From: Patz, Logan W.
To: ["Roger Cinelli"](#)
Cc: [Ortiz, Monica](#)
Subject: H22D026 Resubmit 2400 Marie Park.
Date: Monday, November 28, 2016 3:16:00 PM

I have a few minor comment on the TCL for 2400 Marie Park.

DRAWING TITLE: TRAFFIC CONTROL LAYOUT

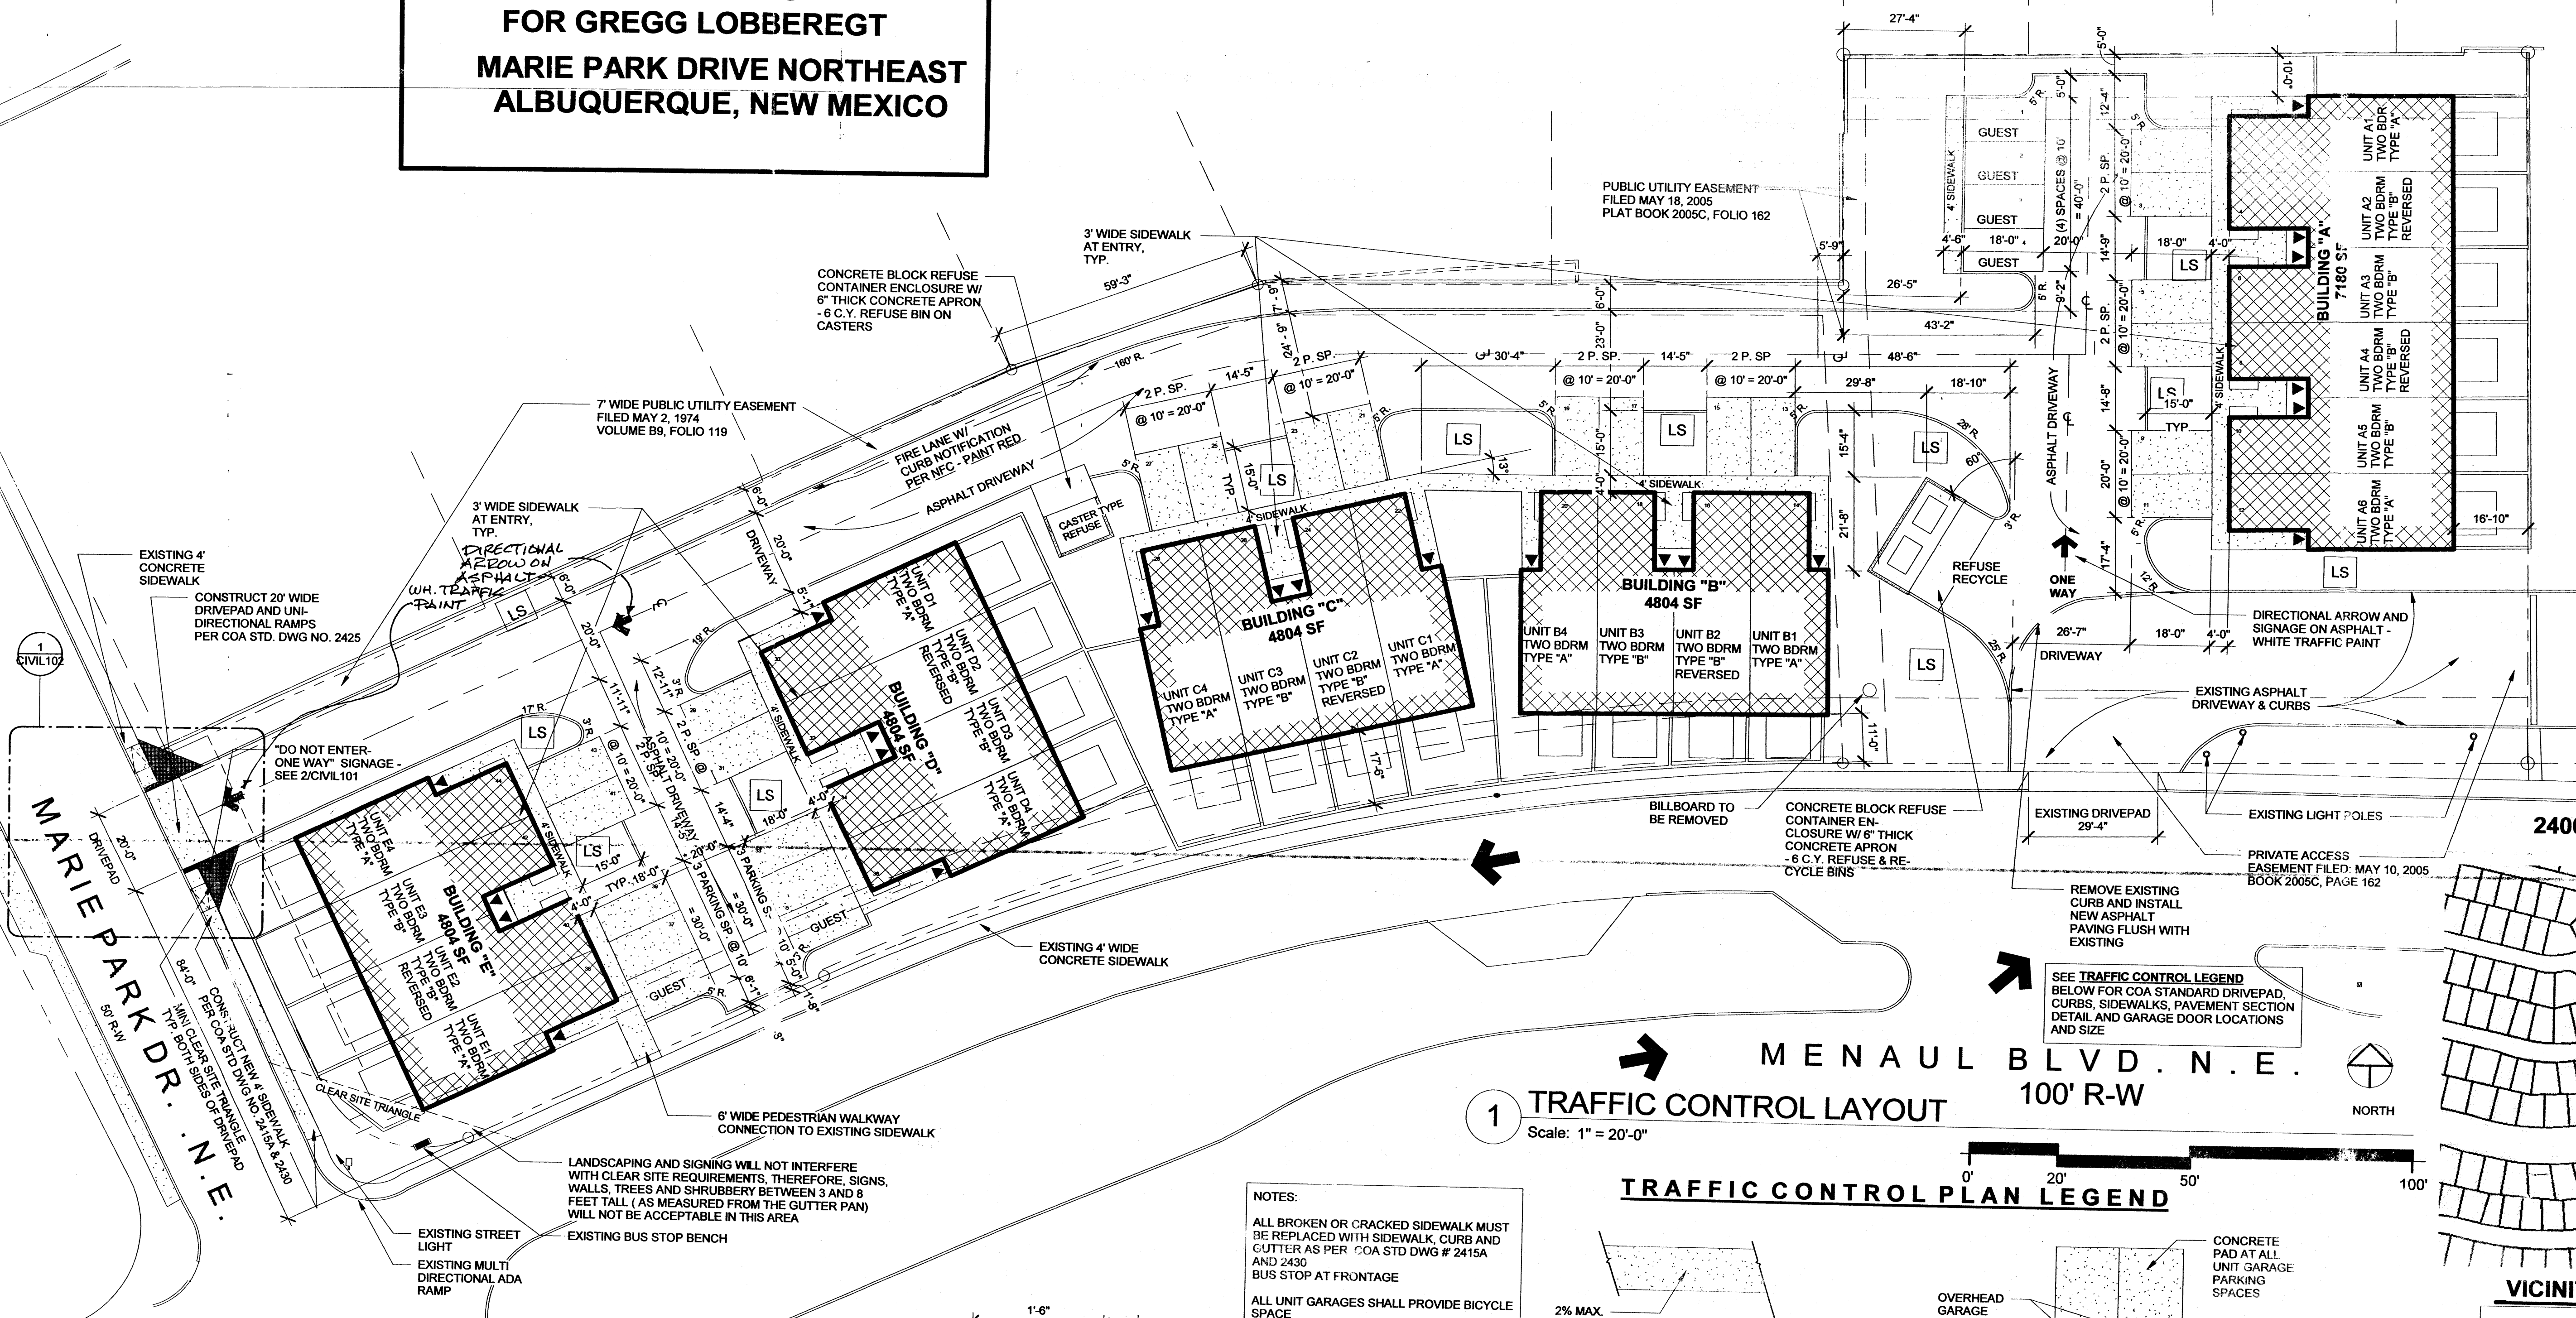
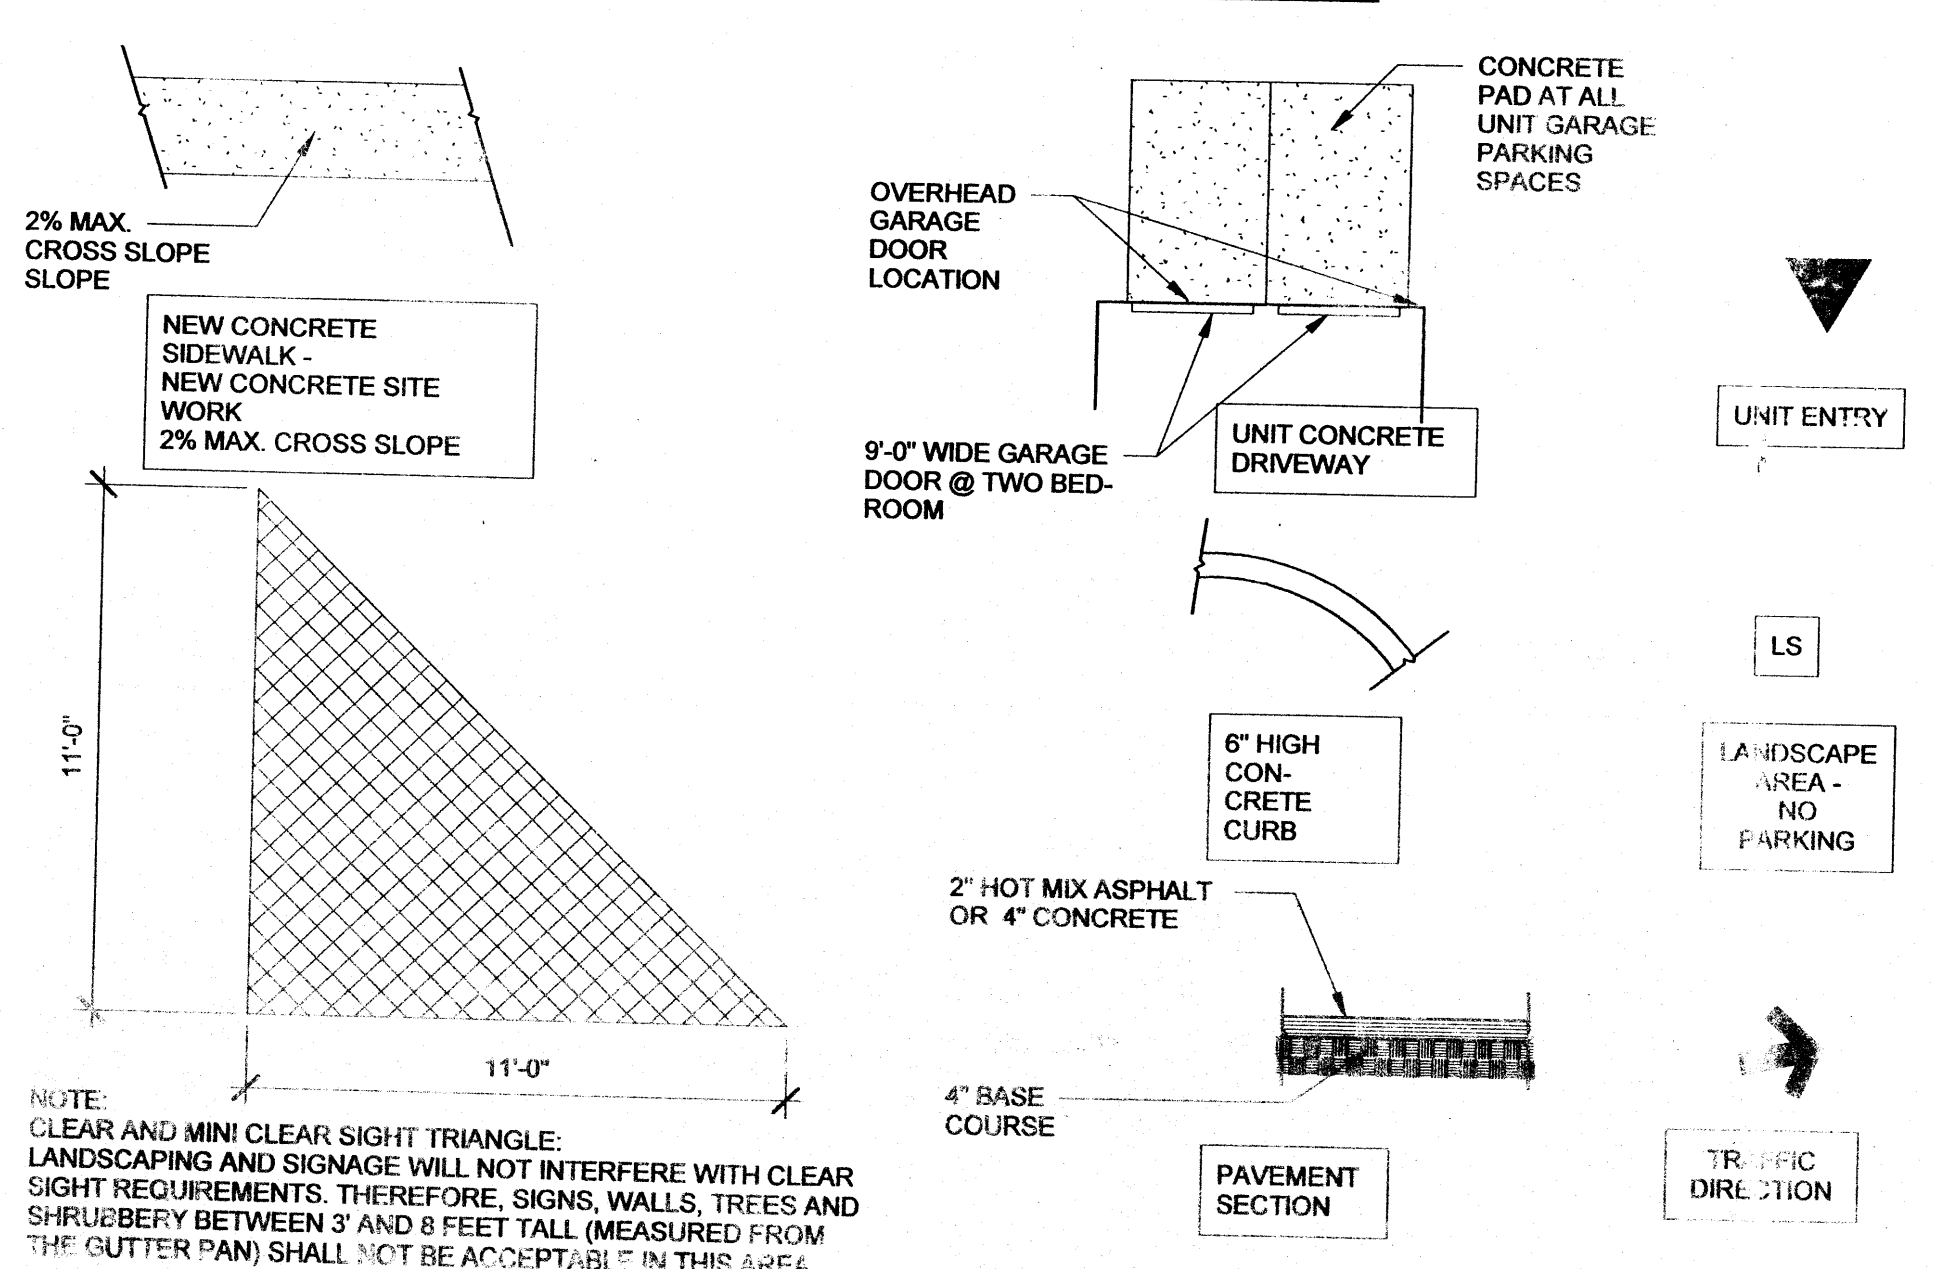
1. The Truncated domes on the second sheet need to be 2 feet wide and should have a note that they will be "Cast-In-Place replaceable".
2. Please add directional arrows at the exit and at decision point along the long road.
3. We will need fire's approval.
